COMMUNITY DEVELOPMENT DEPARTMENT
501 Delta Avenue ♦ Marysville, WA 98270 ♦ (360) 363-8000

Re: M-51 Industrial – *Technical Review 2*
PA 23014

M-51 INDUSTRIAL, LLC
M-51 INDUSTRIAL
PRELIMINARY ROAD SECTIONS

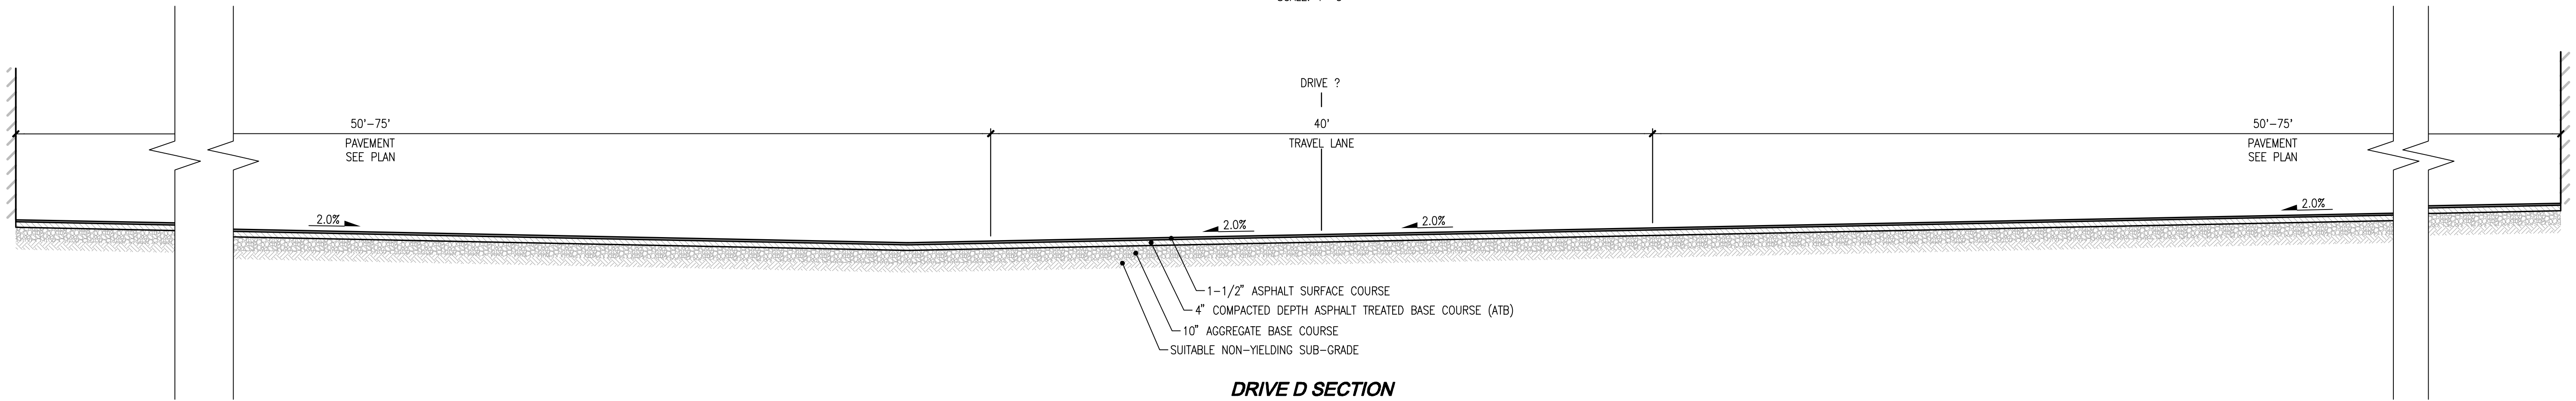
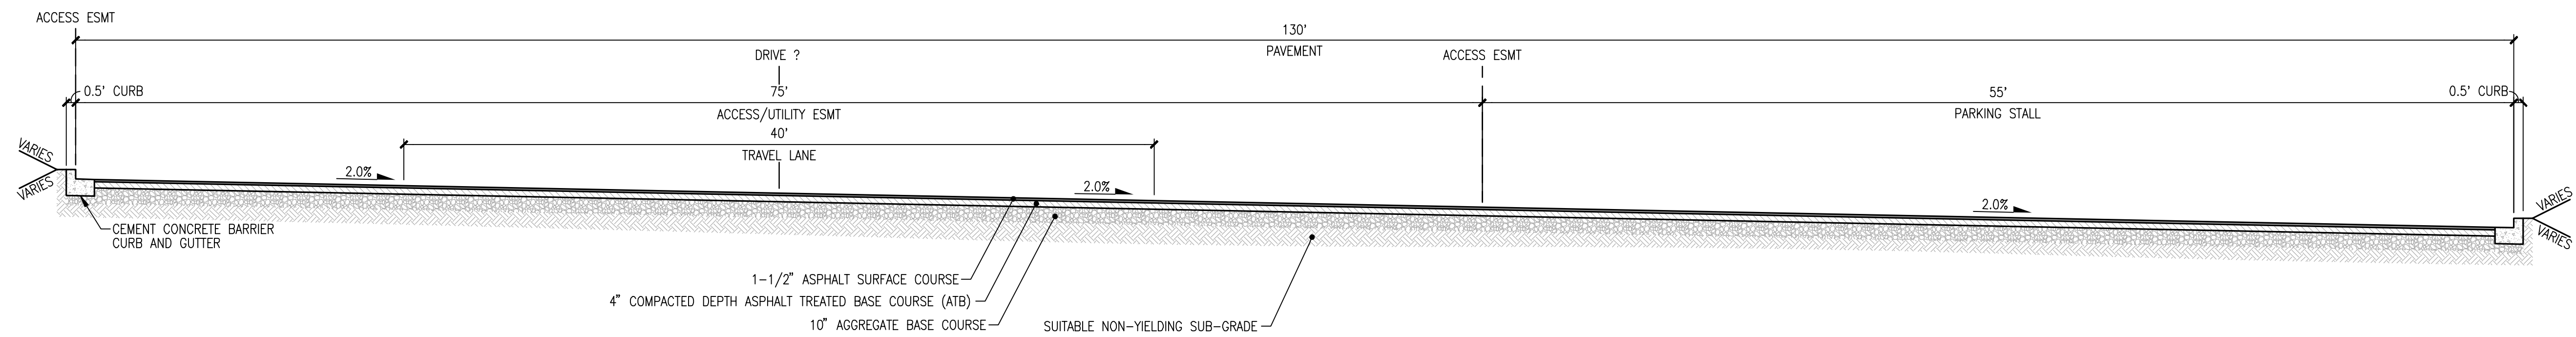
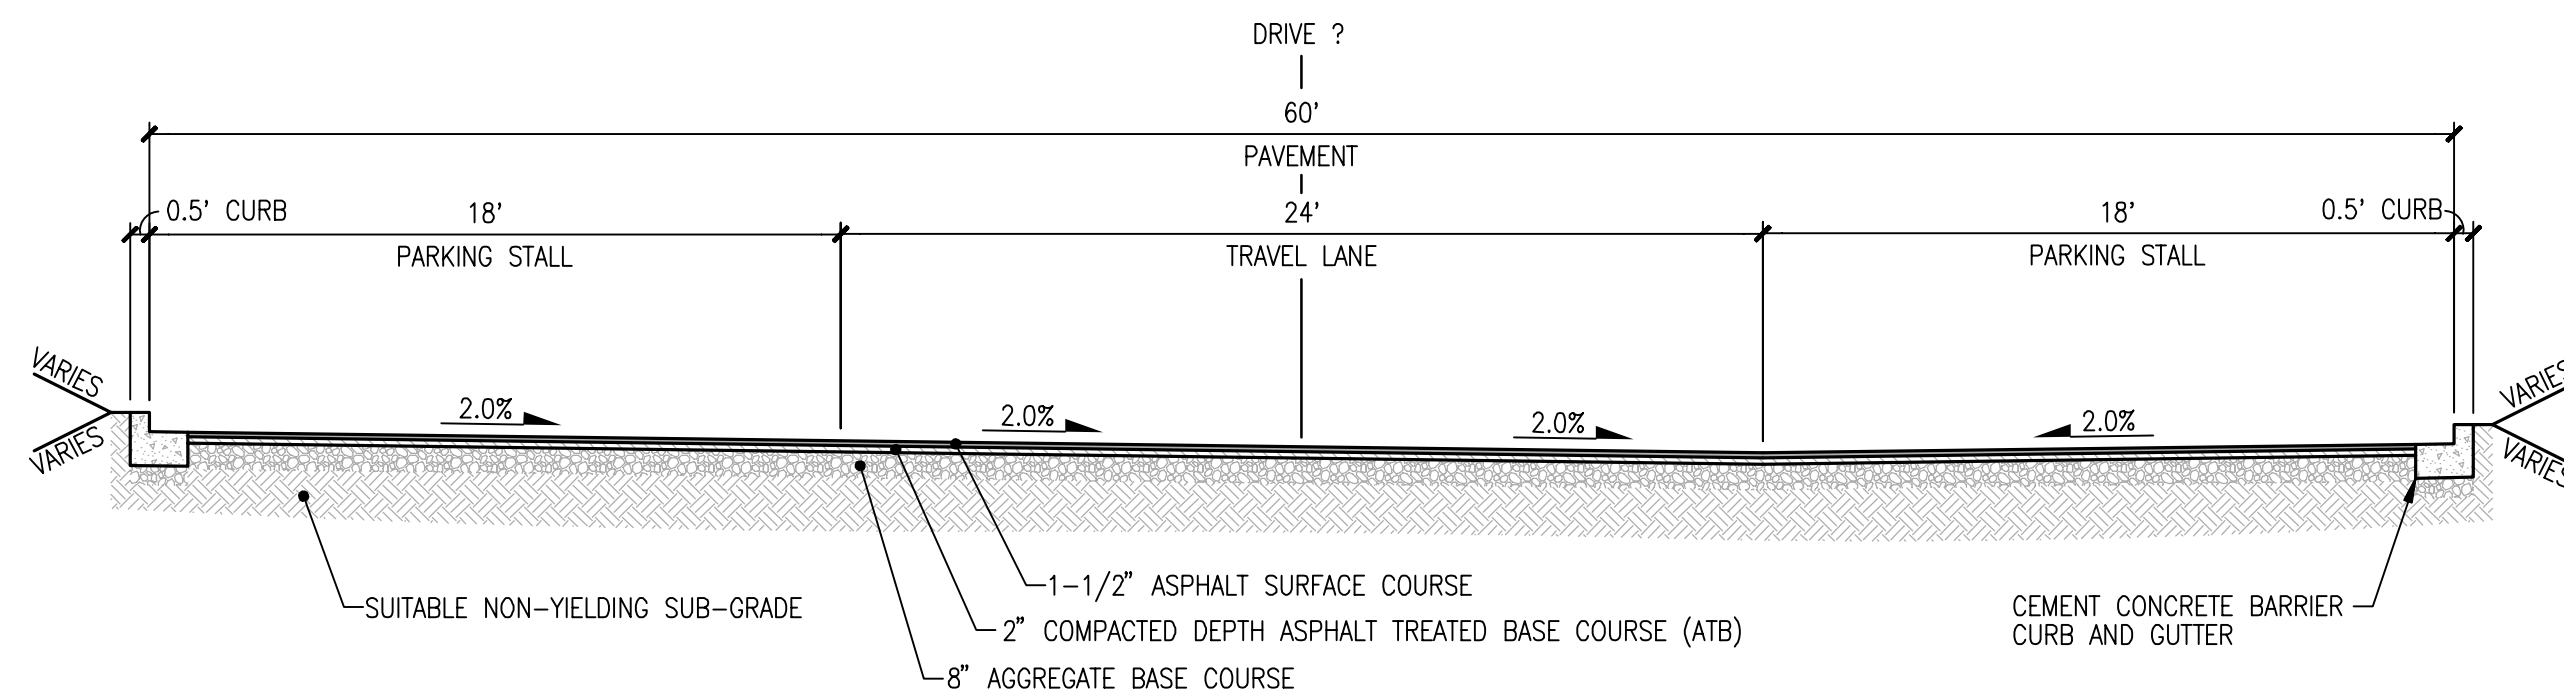
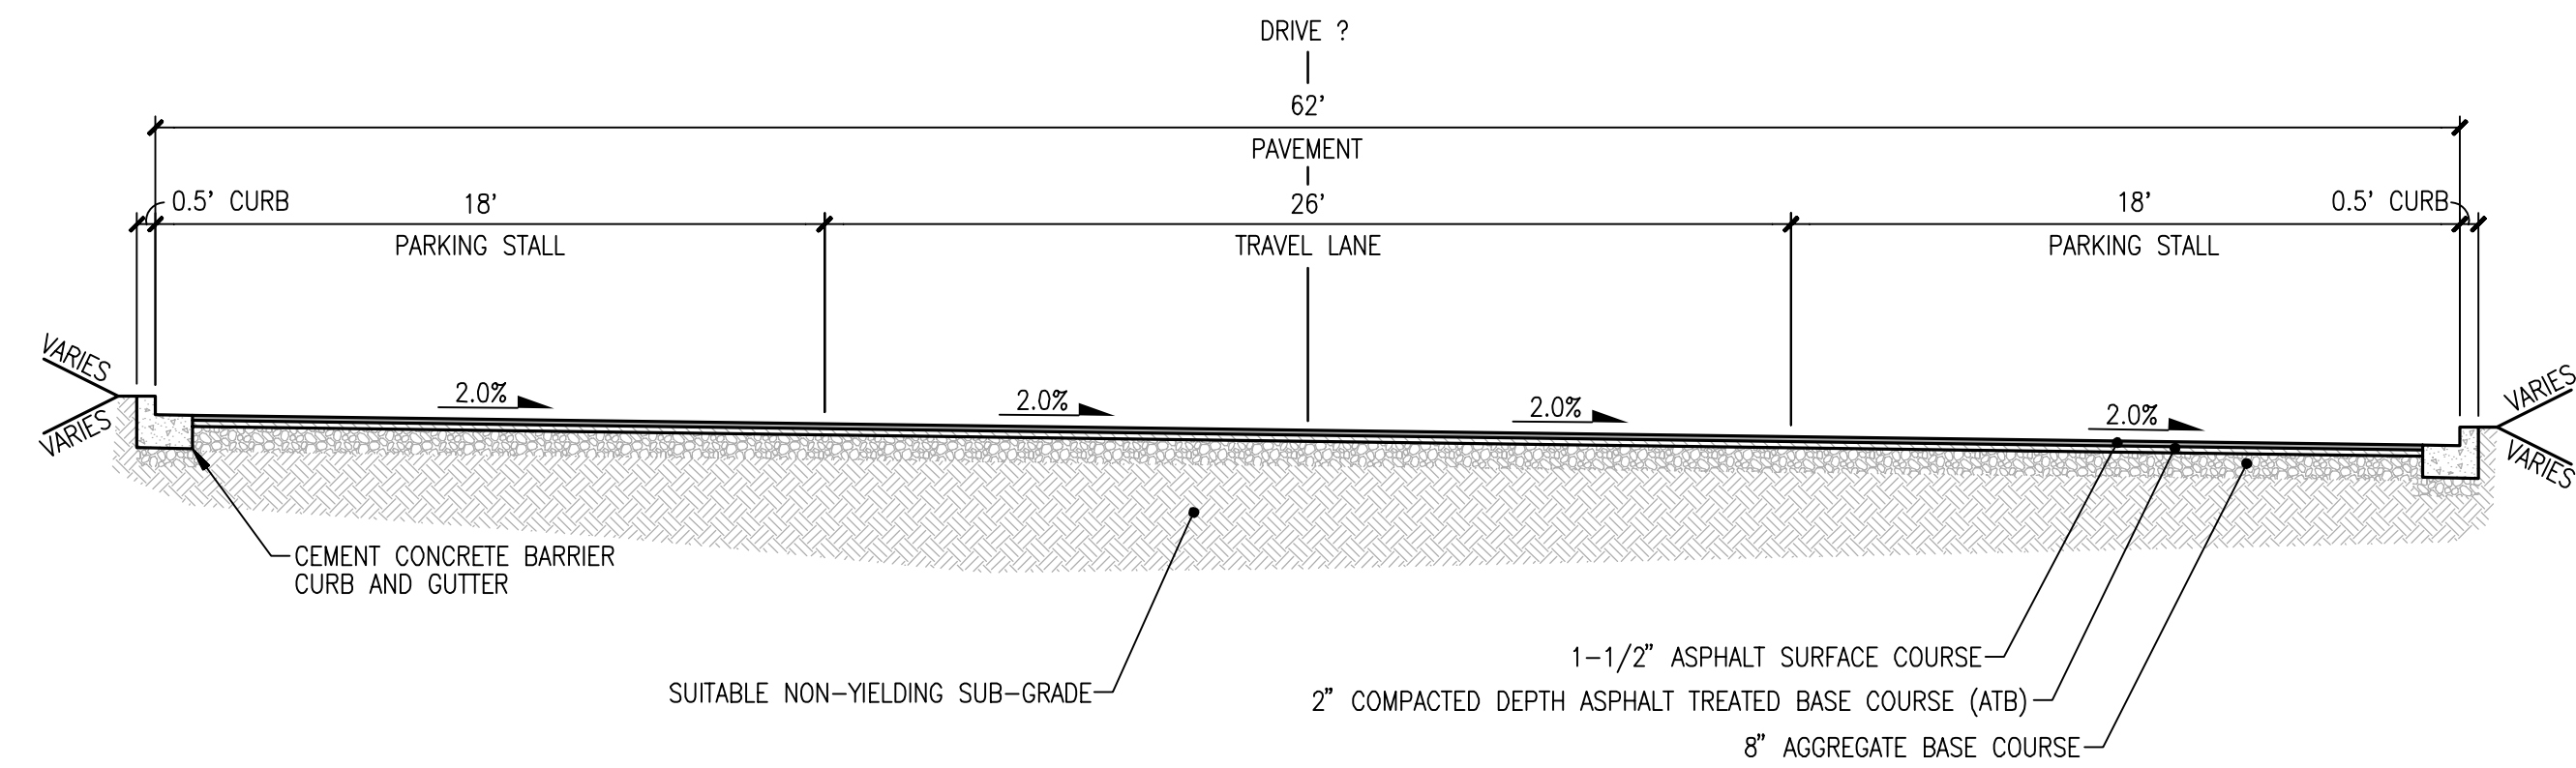
8. Dedication Requirements:
 - a. A 25 foot dedication is required for 51st Ave NE. **A 25 foot dedication is being shown on the supplied plans.**
 - b. A 50 foot dedication will be necessary for 59th Ave. **It was noted in the response memo that a total of 65 feet will be dedicated between this project and the project to the east. As a 12 multi-use path will be on both sides, total right-of-way width will need to be 80 feet.**
